Recommendation Report for Planning Permission for Works or Extension to a Dwelling

REF NO: FP/177/19/HH

LOCATION: 64 Downview Road
Felpham
PO22 8JA

PROPOSAL: Single storey rear extension, porch extension & loft conversion

Proposed Extensions and Alterations Proposed Plans Planning
Date July 2019
Scale 1:50

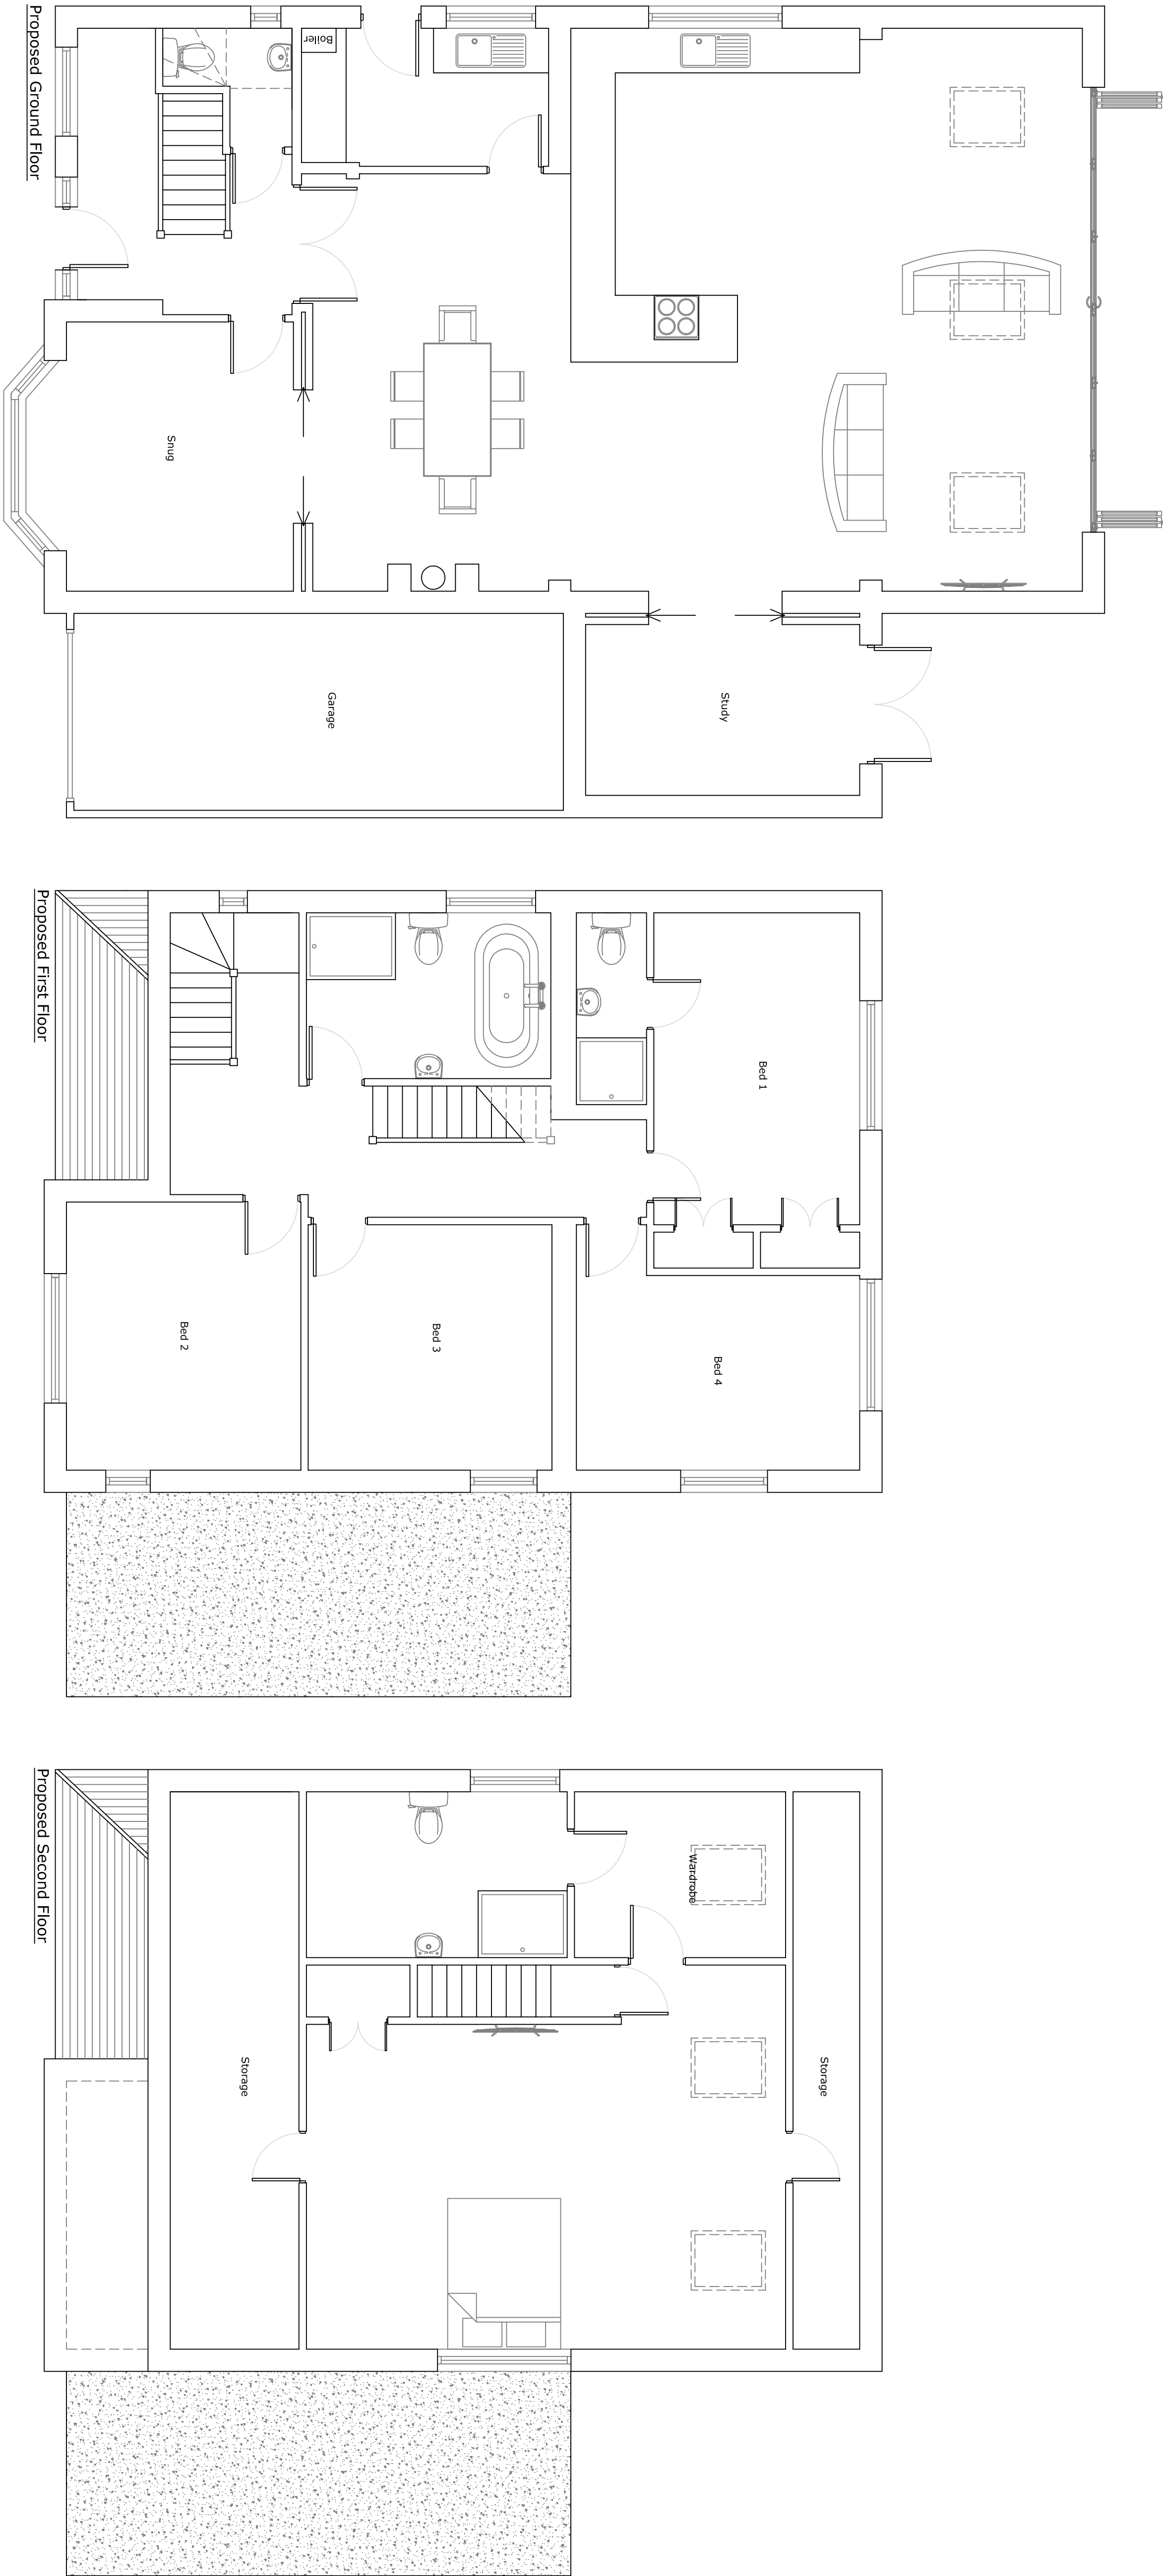
The extension will be sited to the rear of the dwelling. There will be an extension to the rear of the existing garage with a depth of 4m. The existing rear elevation will then increase by 3m.

The extension to rear of the garage will have a flat roof with a height of 2.65m. The rear extension will have a lean-to roof with a height of 3.4m reducing to 2.3m. The garage extension will sit close to the boundary at No.62 however the neighbouring property extends further to the rear and with no windows to the side elevation at the neighbouring property or extension it is not considered to result in adverse overbearing or overshadowing.

1.5m and 2.5m will retained to the side boundaries from the rear elevation and the development does not extend beyond the rear of neighbouring properties. As a result, it is not considered to appear overbearing upon neighbouring amenity. The extensions will have doors to the rear and with no side windows proposed, views will be of the rear garden of the host dwelling.

Proposed North Elevation

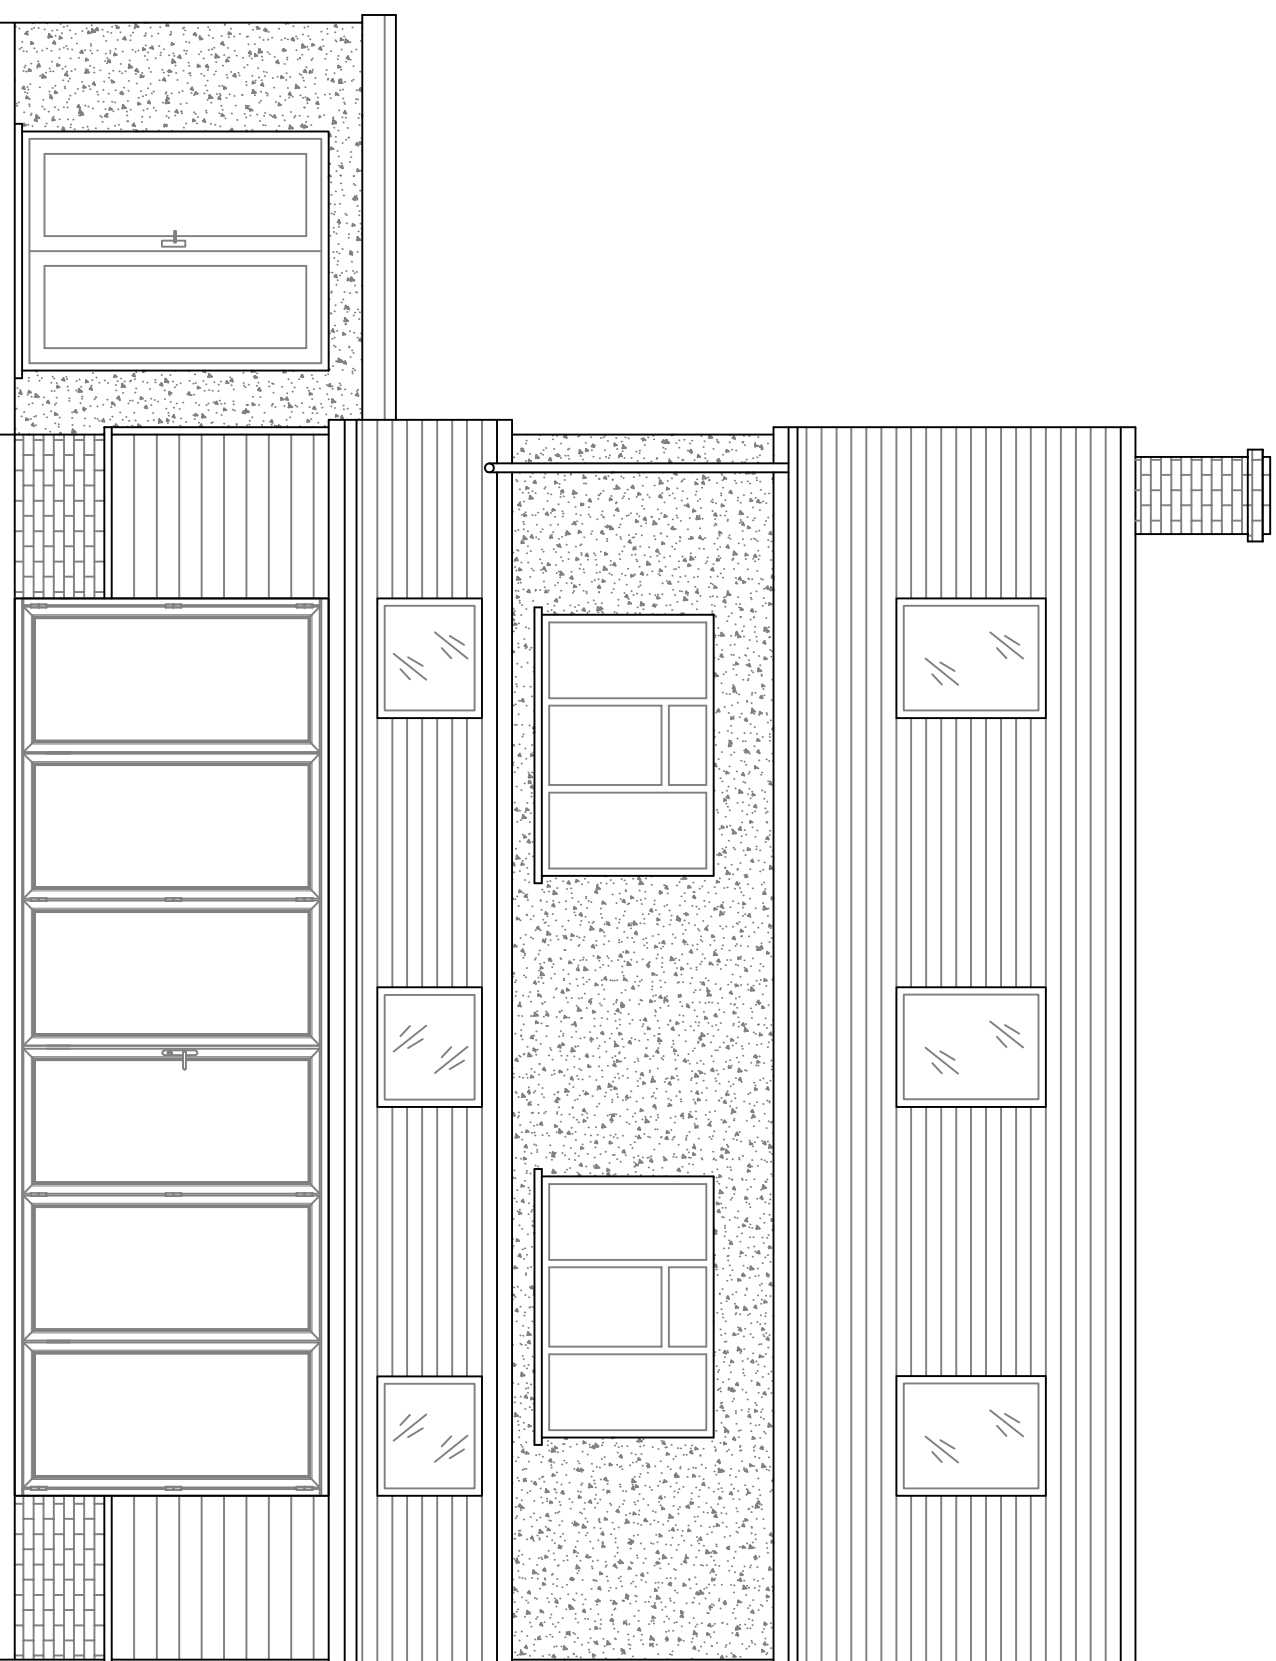
The loft conversion will install 3 velux to the east and additional windows to the north and south elevations. There will be 3 additional windows to the northern elevation with 1 at ground floor, 1 at first floor and 1 in the roofspace. The windows sited above ground floor will serve bathrooms however the window to the second floor may have potential for overlooking into the neighbouring velux and therefore it will be conditioned to remain obscured glazed but not fixed shut.

- 3 The window to the northern elevation on the second floor of the building shall at all times be glazed with obscured glass.

Proposed South Elevation

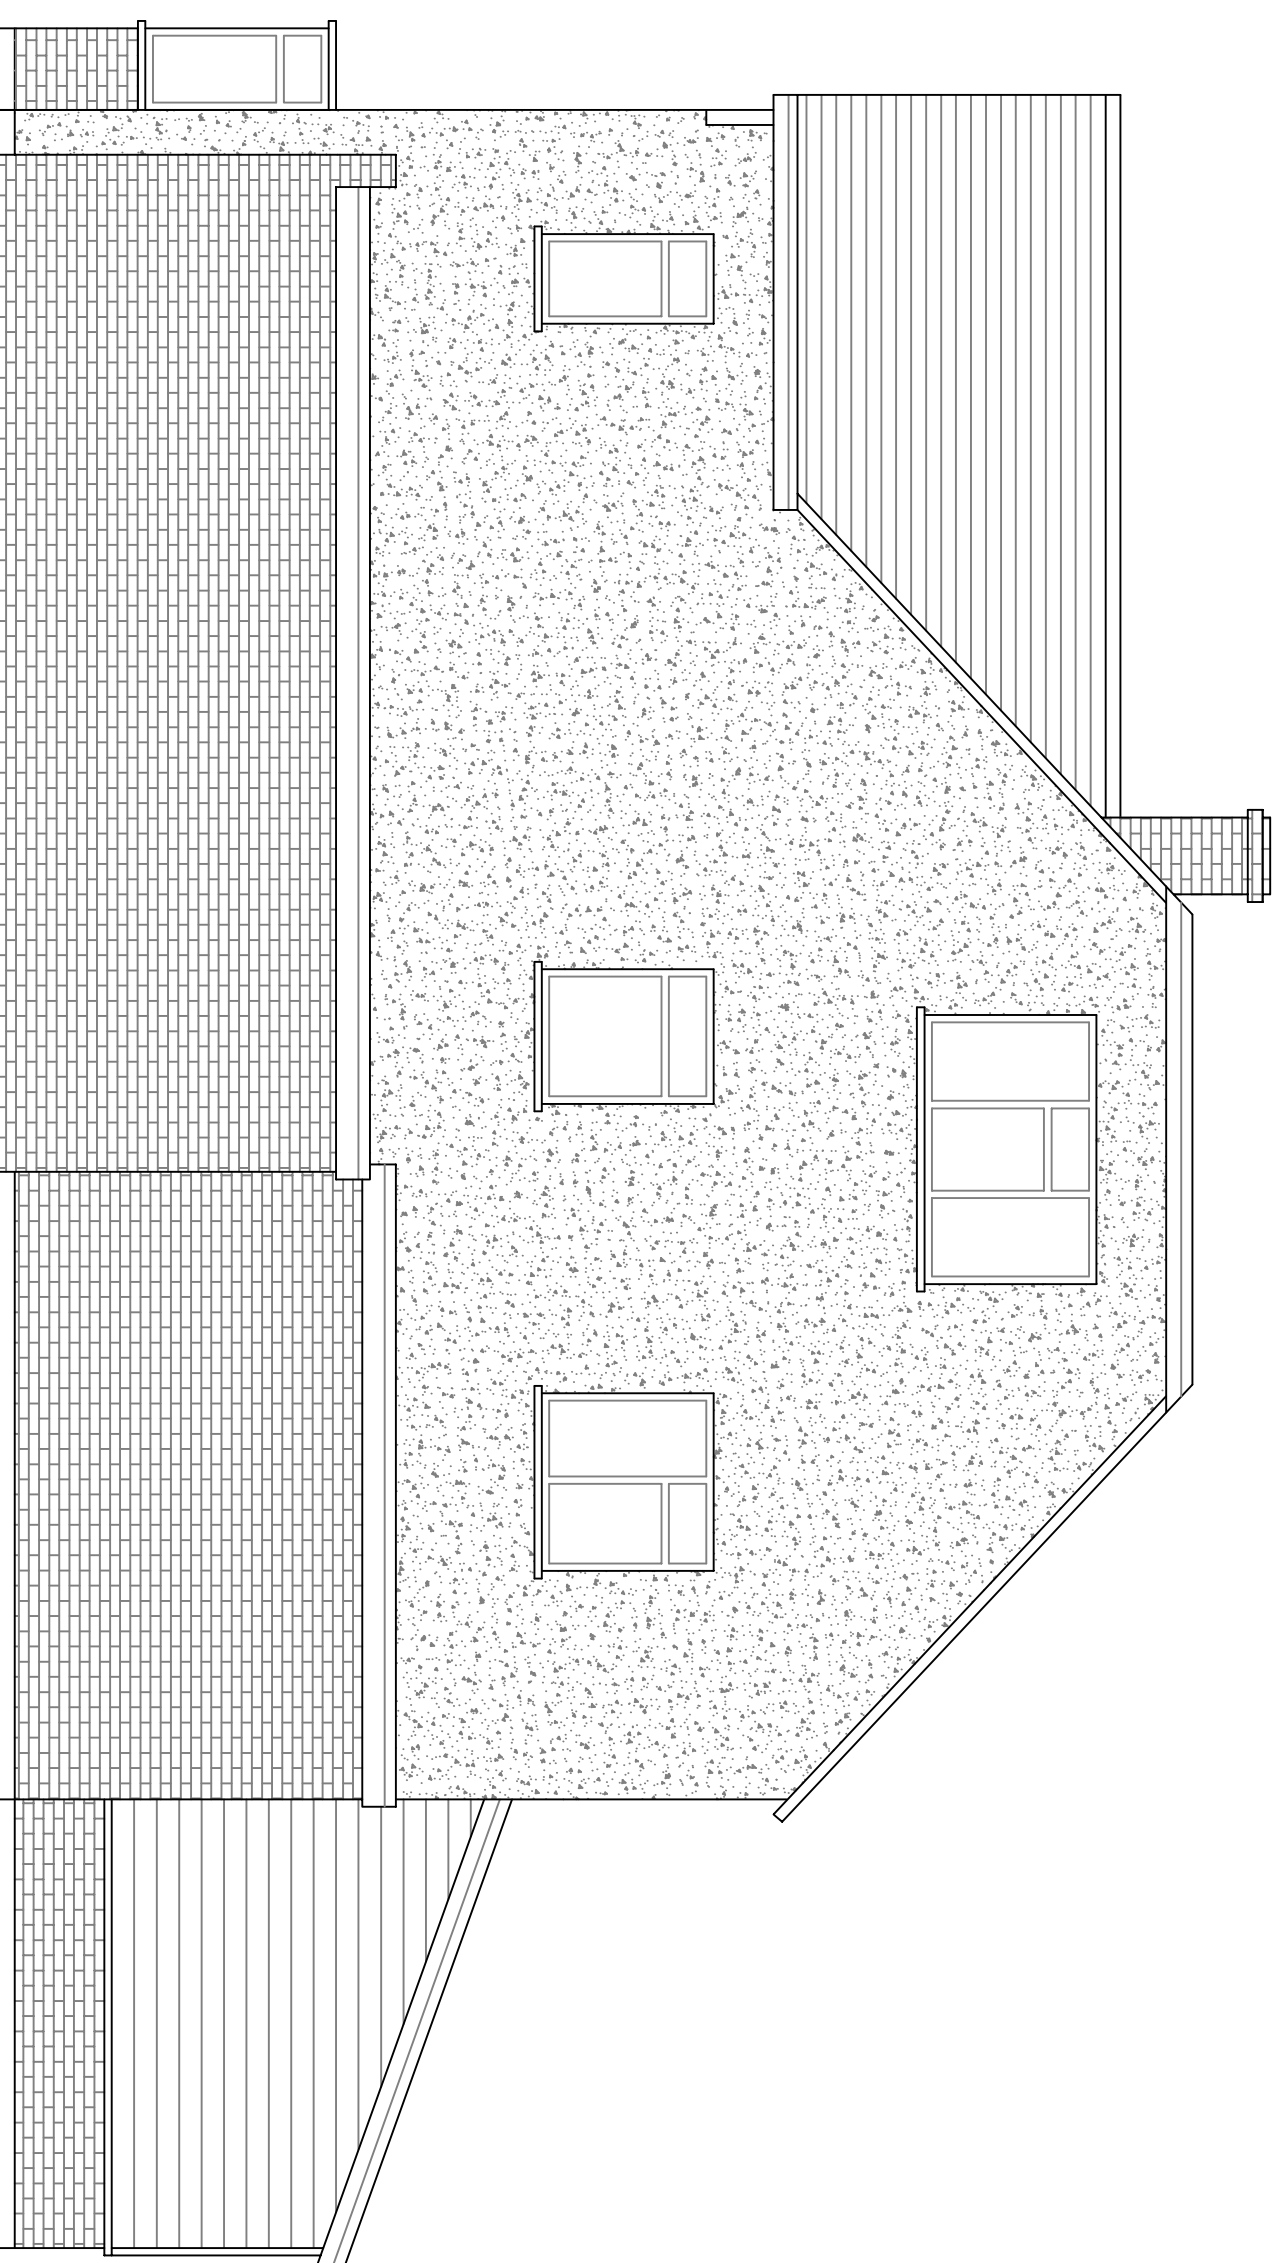
To the south, a second floor window will serve a bedroom. Whilst this may have the potential to overlook

neighbouring properties, it is not considered to give rise to direct views into neighbouring windows and with the properties at single storey, the window is not deemed to result in adverse overlooking.
